**Our Case Number:** ABP-318573-23

**Re:** A proposed Road Development comprising of the N2 Slane By-Pass and Public Realm Enhancement Scheme  
Within the Townlands of Slane, County Meath

**Re: HA17.318573 - Proposed Road Development comprising of the N2 Slane Bypass and Public Realm Enhancement Scheme [LA ROAD DEV – Application] and associated Environmental Impact Assessment Report (EIAR) and Natura Impact Statement (NIS).**

Figure 13.31: Viewshed from Knowth, with Proposed Scheme Alignment Shown in Light Purple (Viewshed produced using Digital Surface Model, which shows surface features such as trees & hedges)

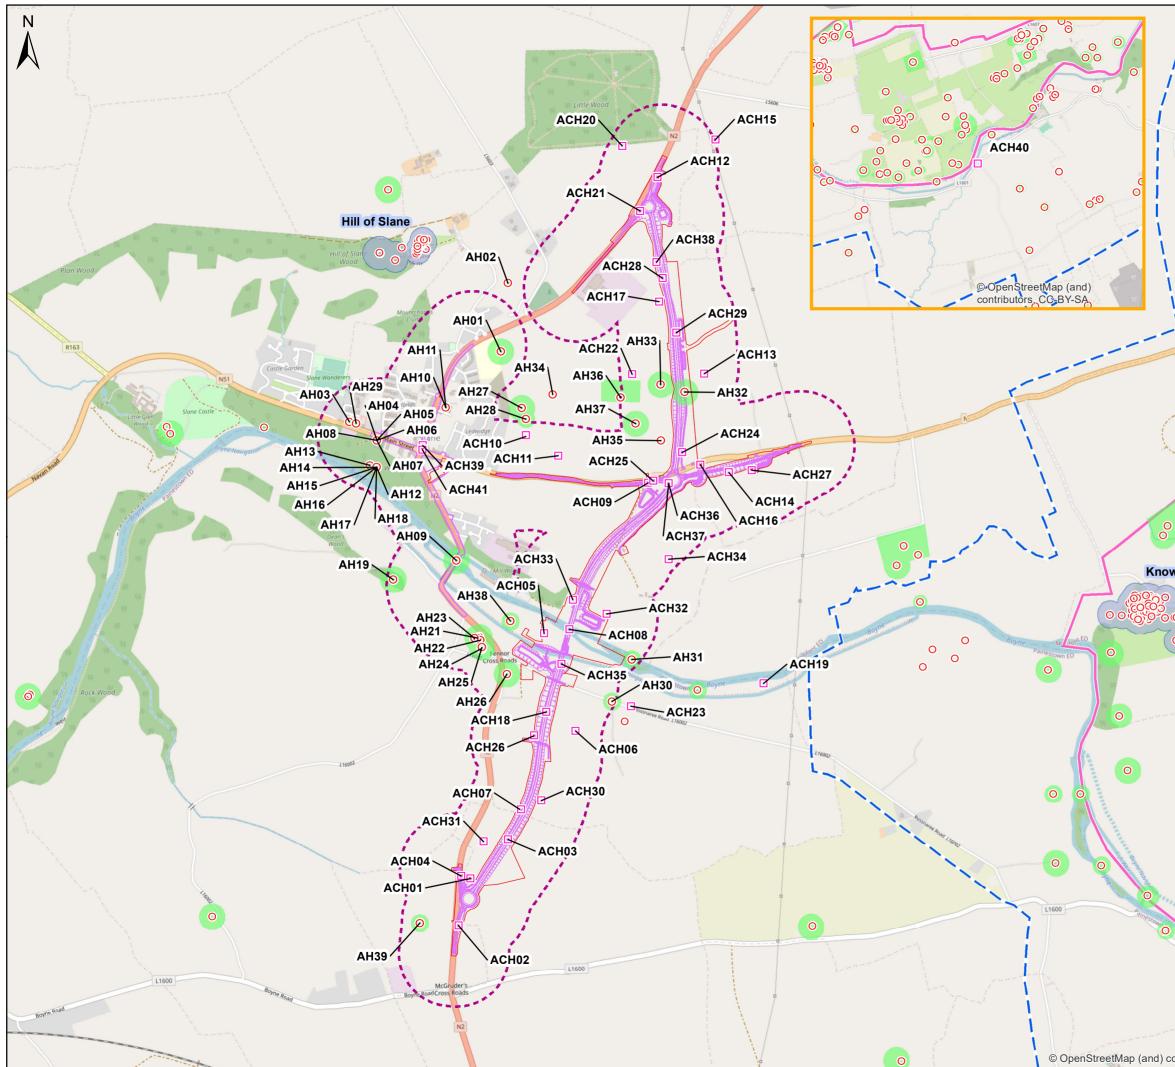
There is a recognition that the scale and prominence of the road network is rightly identified as increasing at a local level. However, the specific evaluation of the wider operational phase impacts in the LVIA is difficult to reconcile with the view of the Landscape Character Assessment of the Meath CDP 2021-2027, that it would be difficult for a linear road to be accommodated. While maturing of vegetation will aid this accommodation there is a need for the viewshed analysis to fully inform this assessment.
